REVISION/DEFERRED SUBMITTAL FORM

Revision Log

Permit: #2012-200

Project Address: 3310 97th Ave SE, Mercer Island, WA 98040

MAIN LEVEL FLOOR PLAN
A2.03

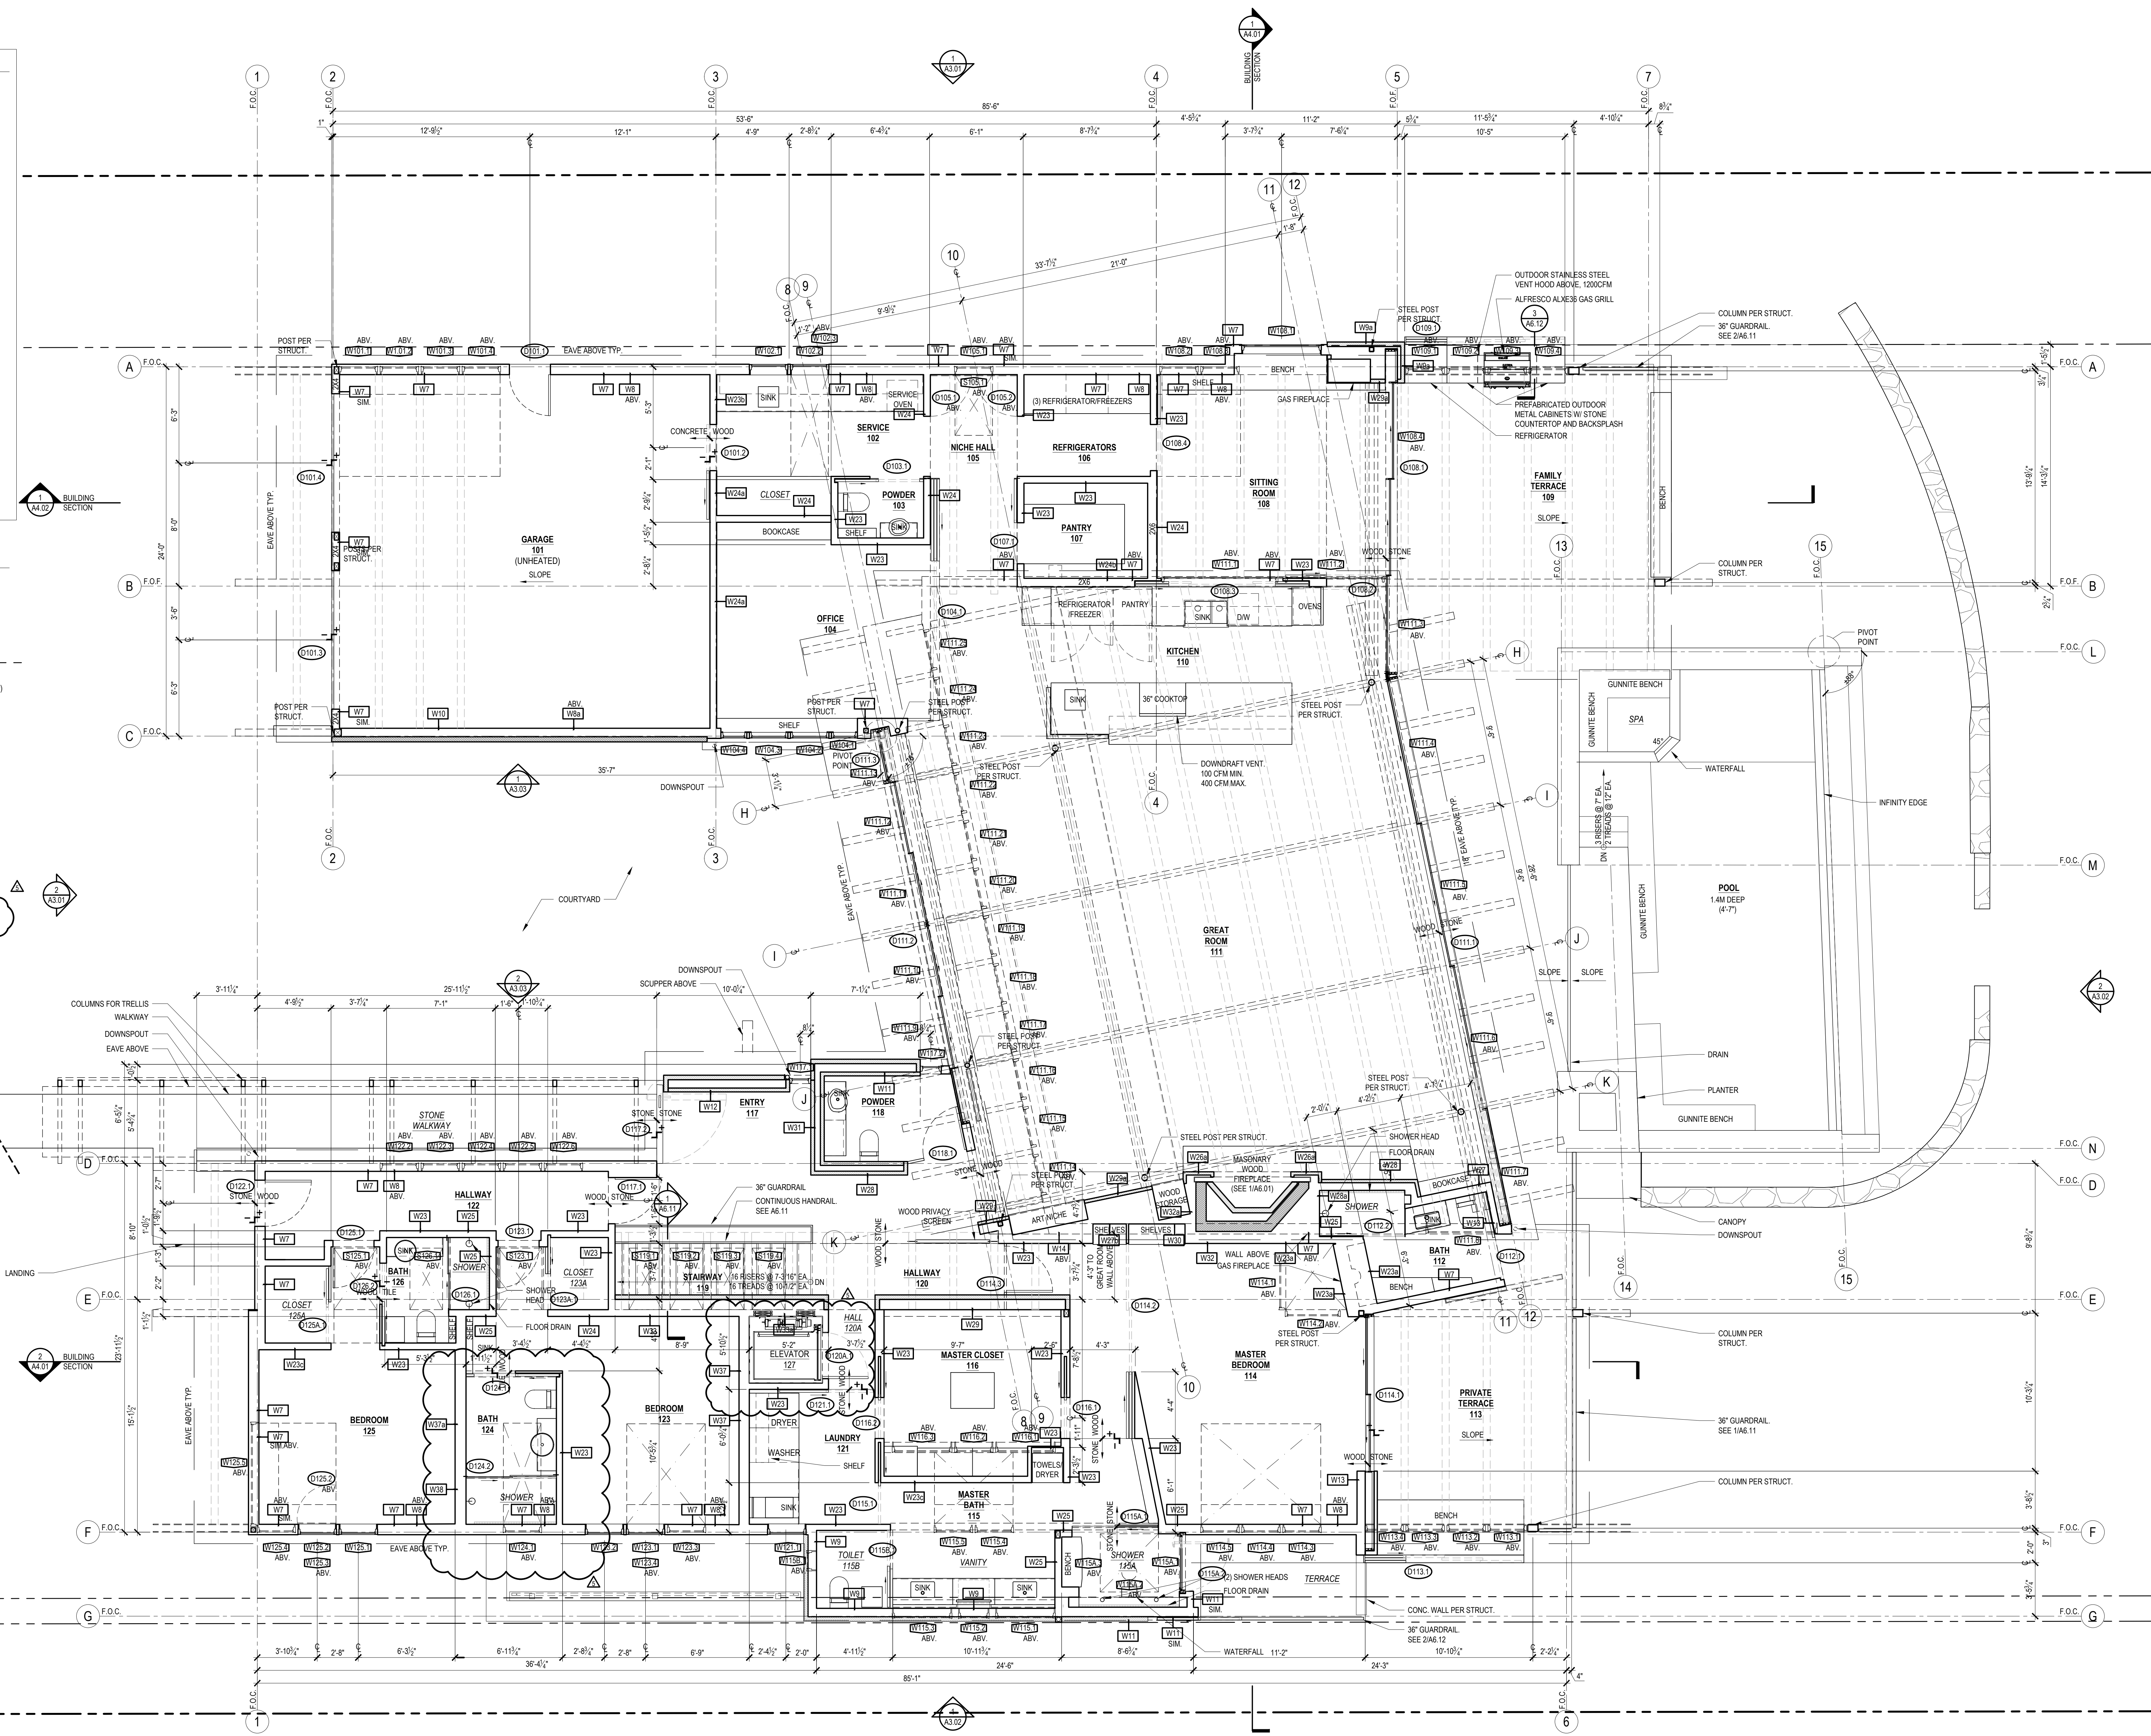
- Revised the floor plan around the new ELEVATOR 127 and HALL 120A
- Added note #6

ACCESSORY BLDG FLOOR PLAN
A2.05

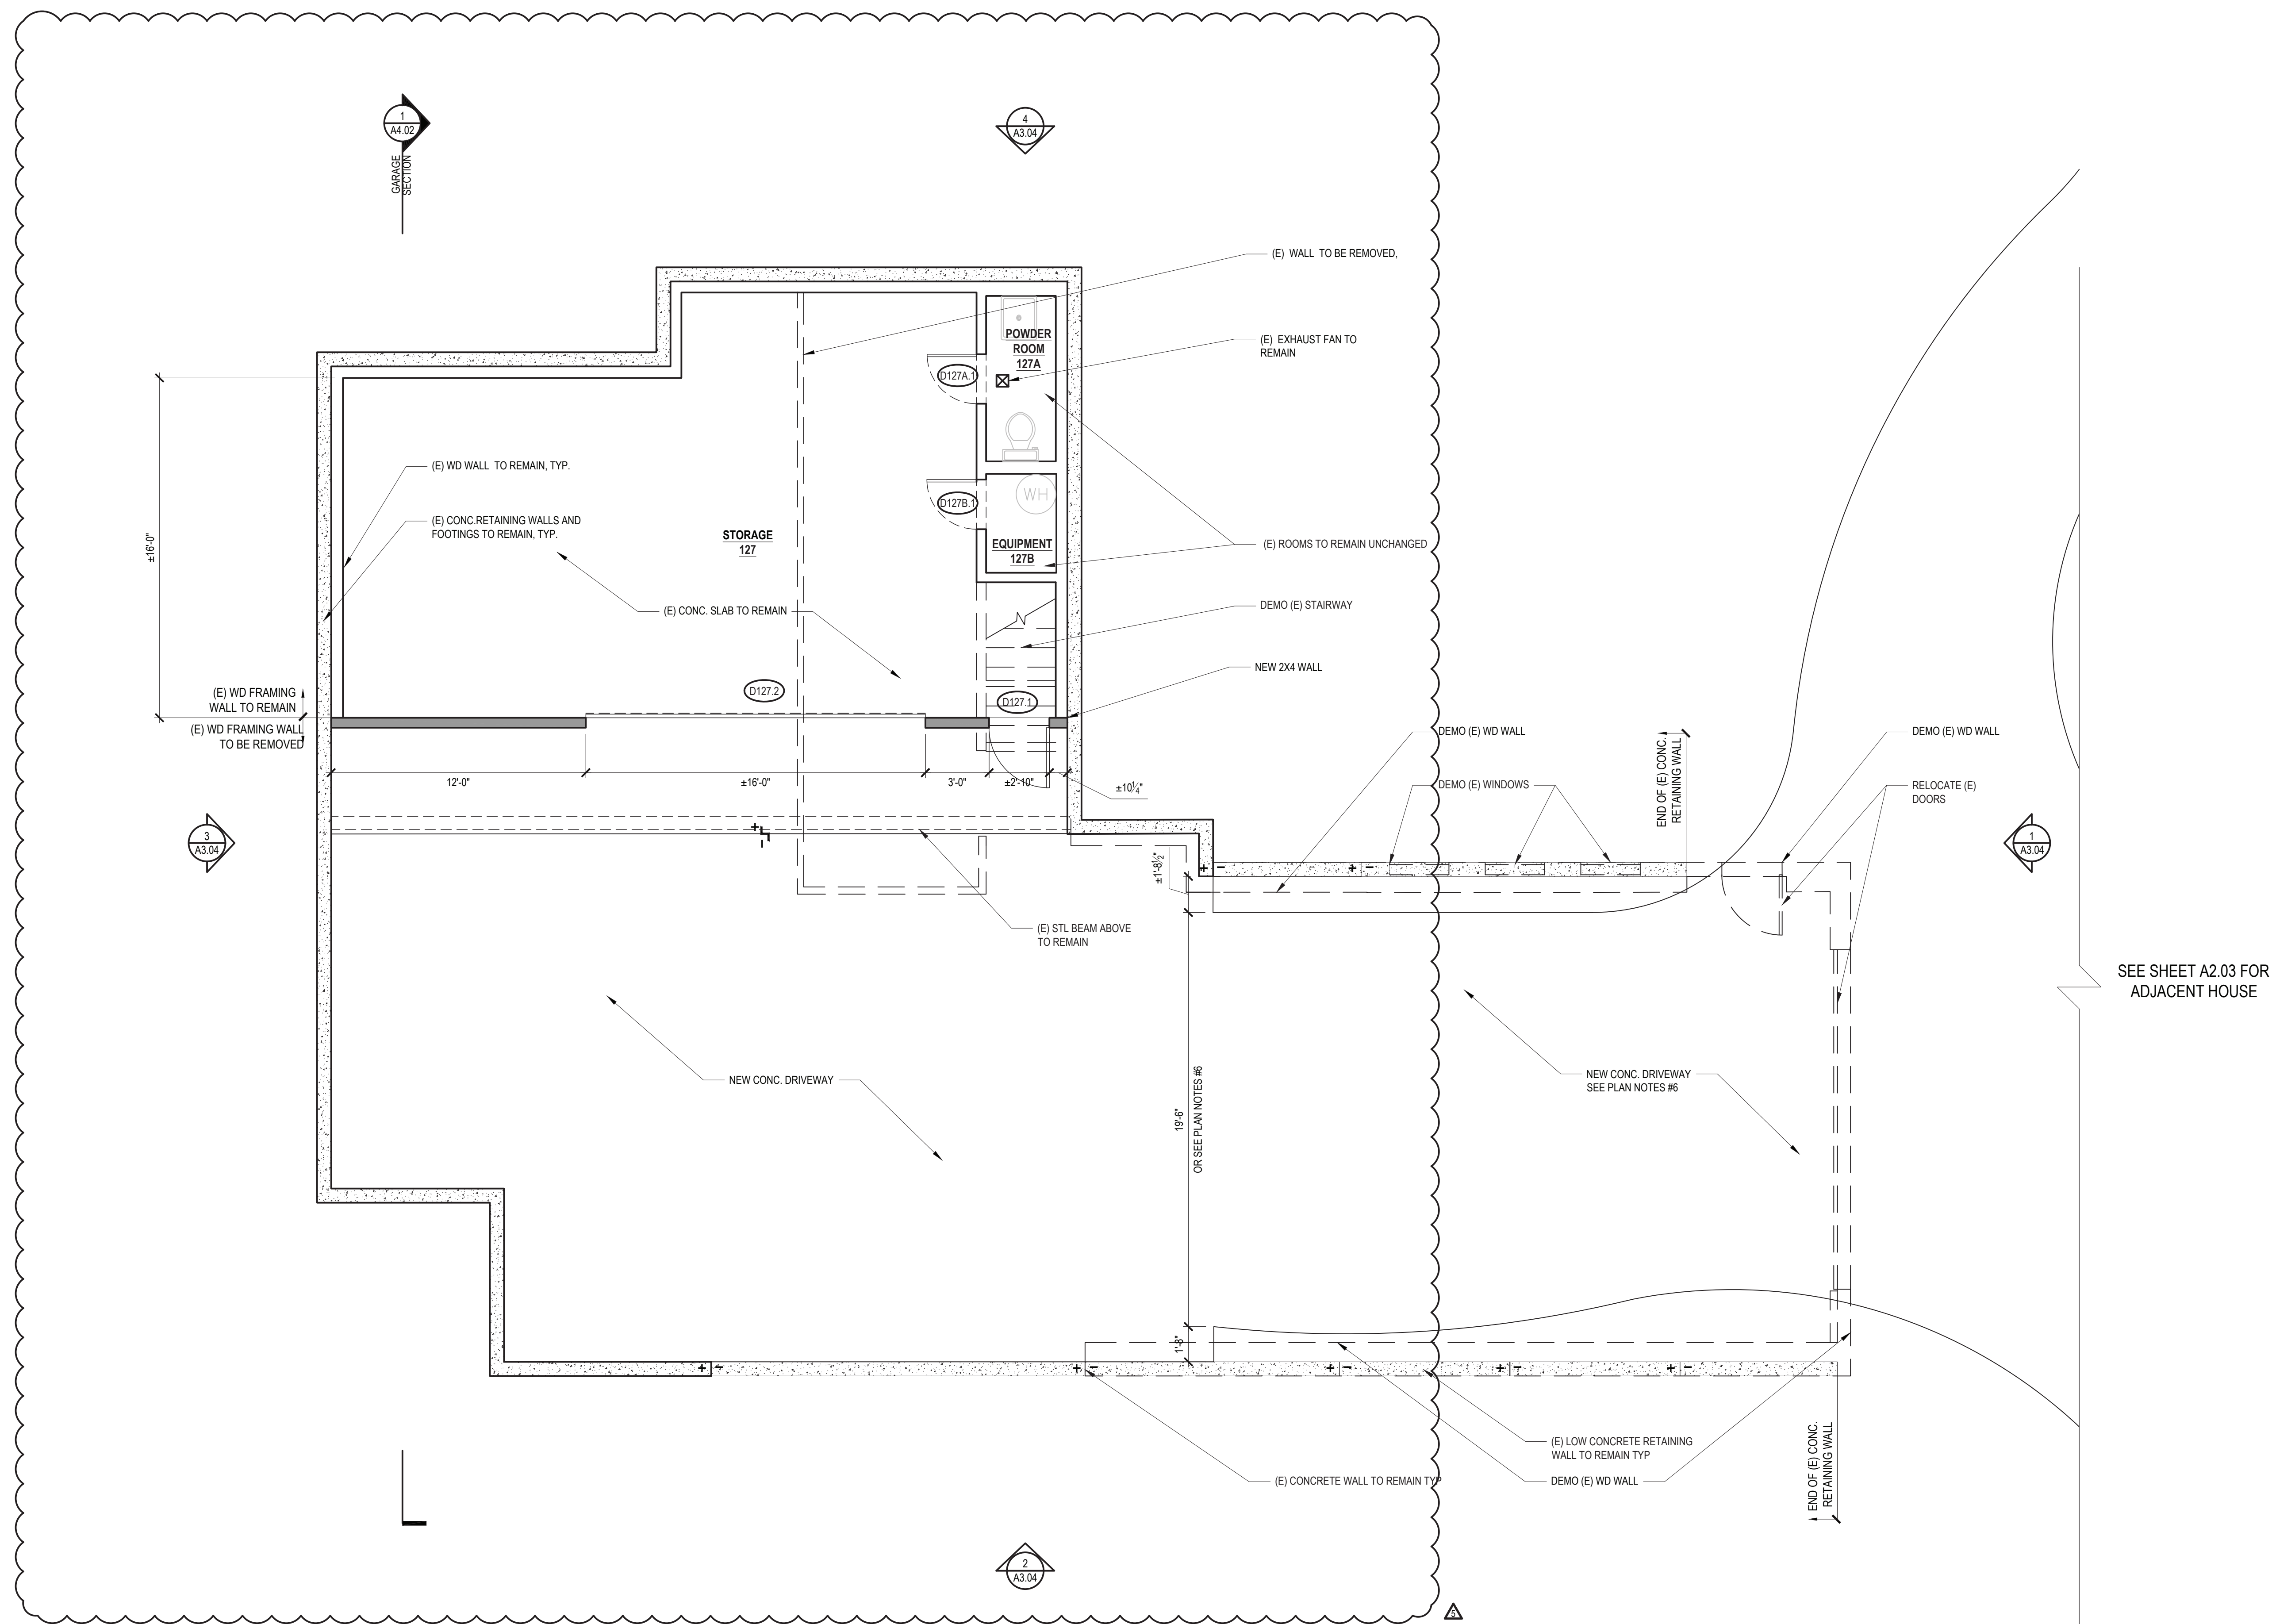
- Revised the accessory building footprint, and relocated the existing garage door and swing door

1 ROOF PLAN
1/4" = 1'-0"

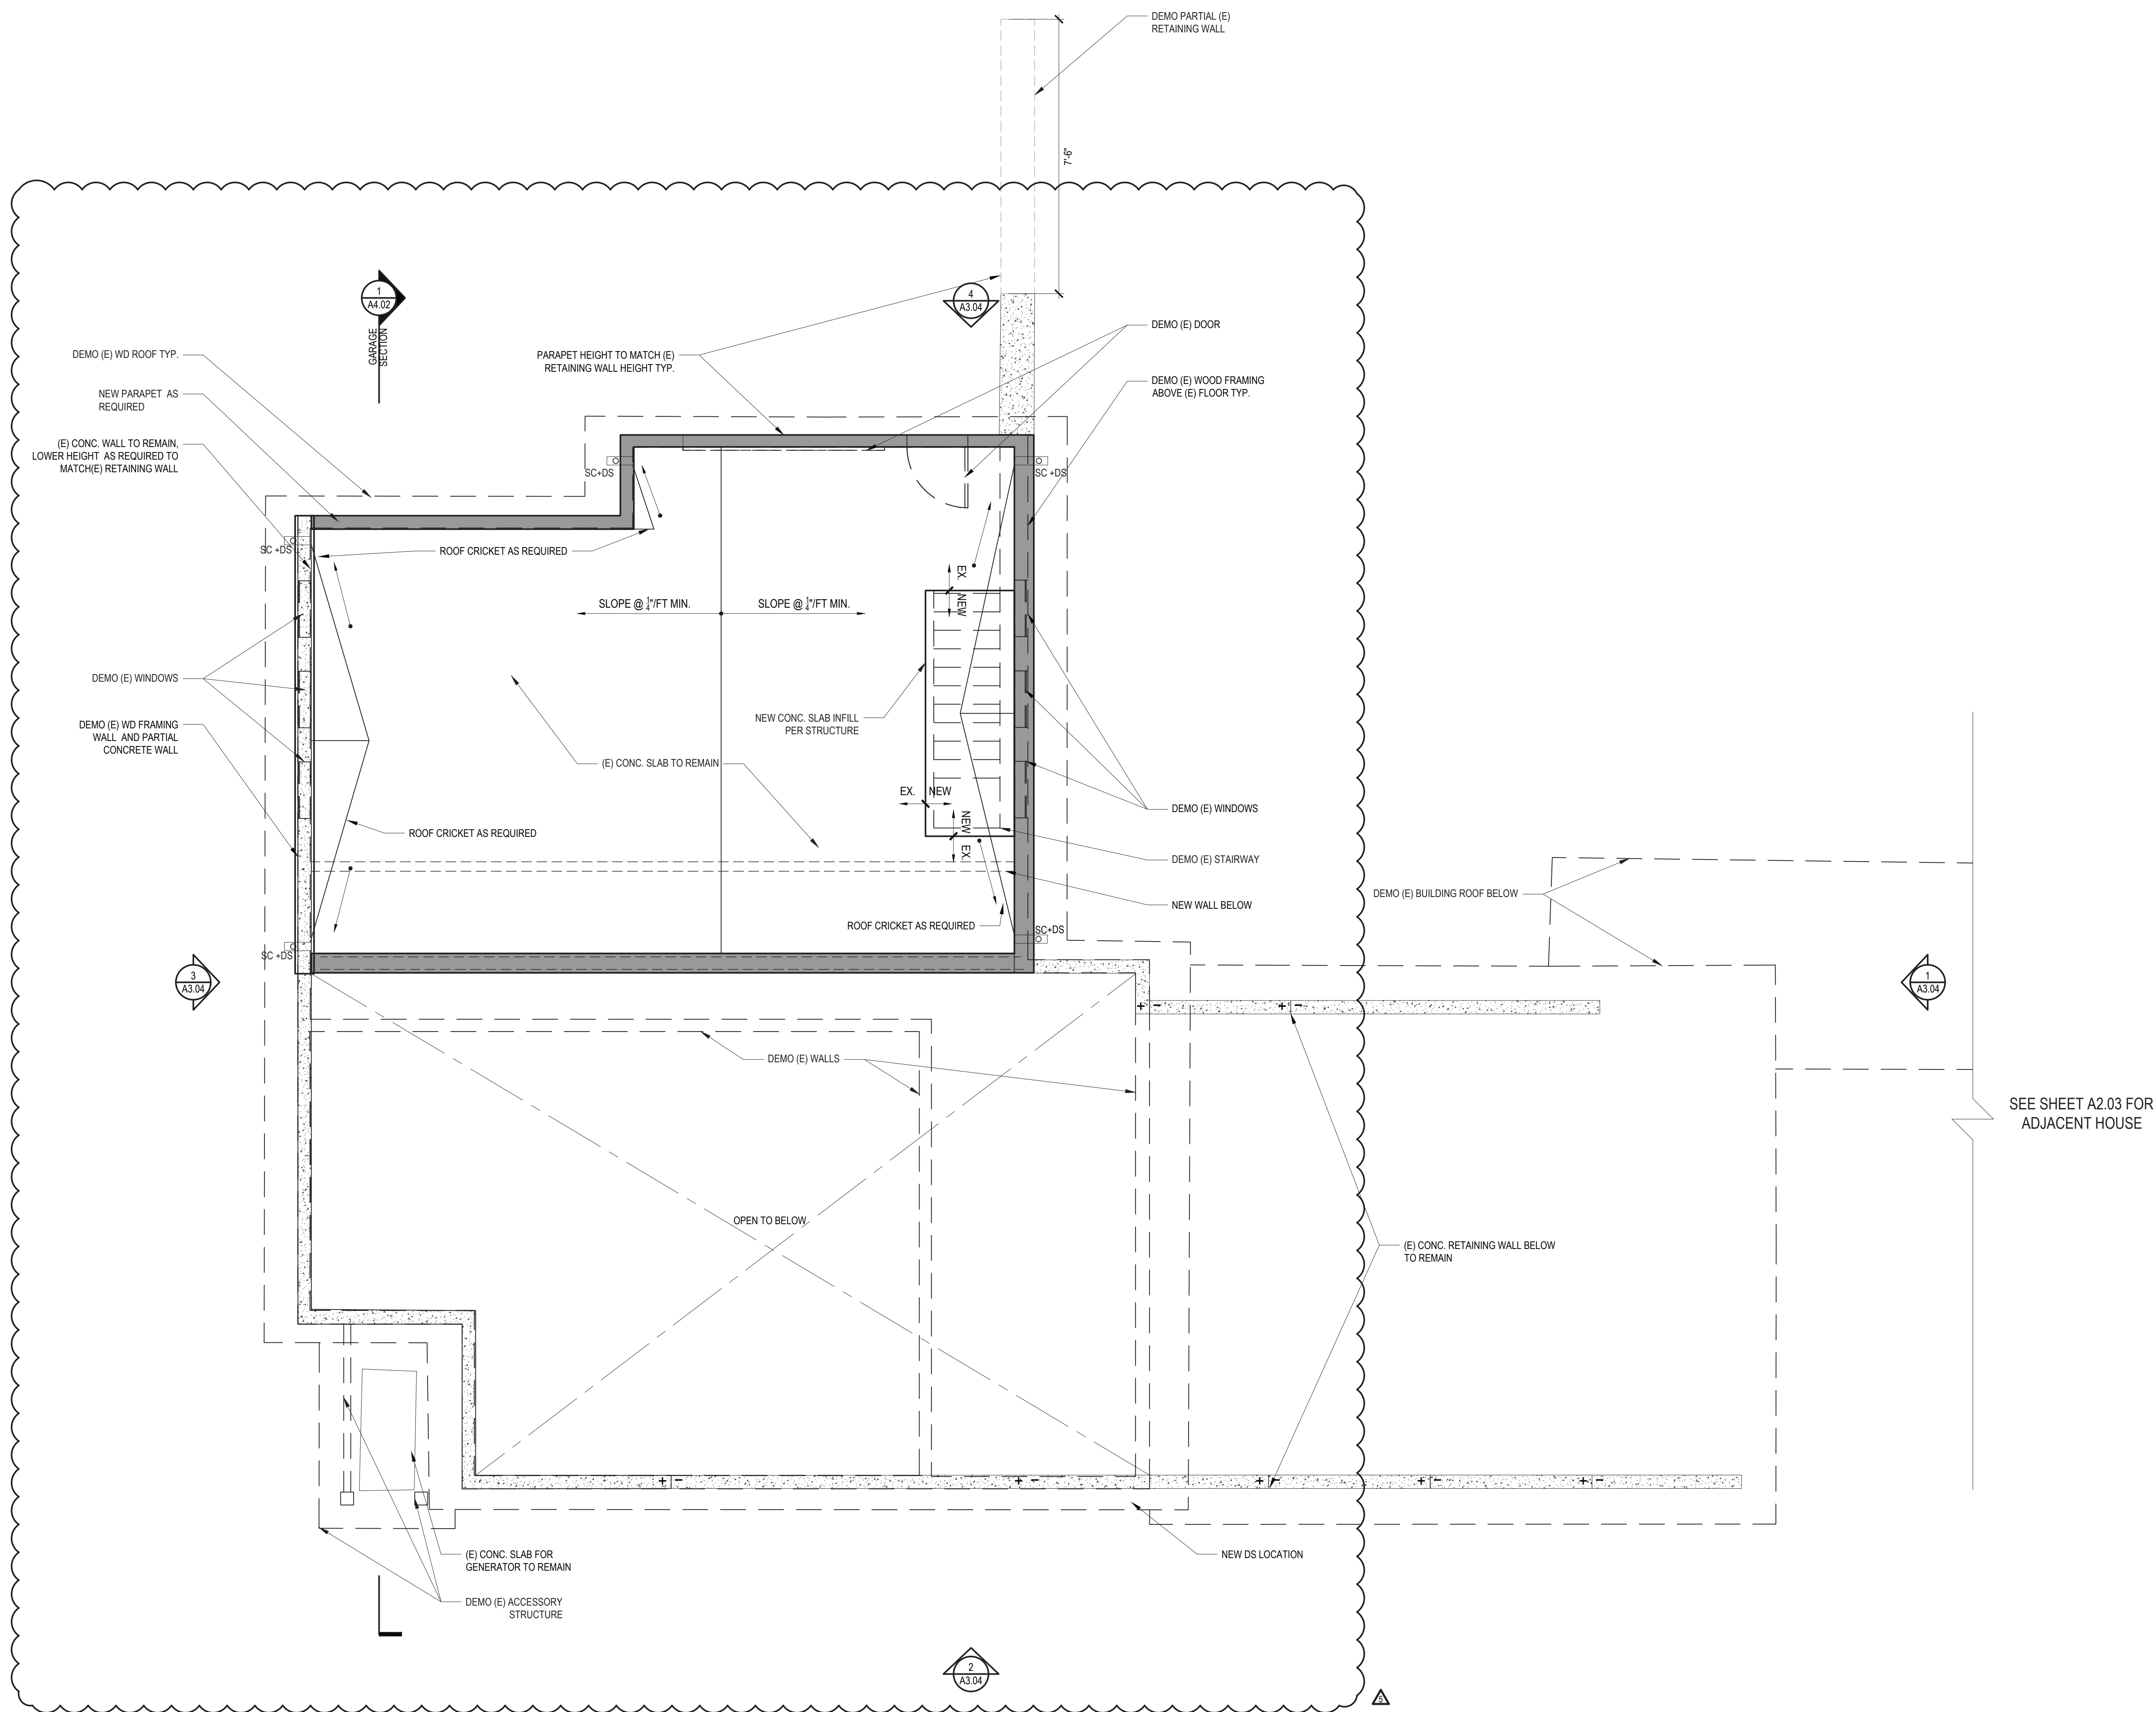
- Revised the roof configuration, demolished several existing beams, and relocated downspouts
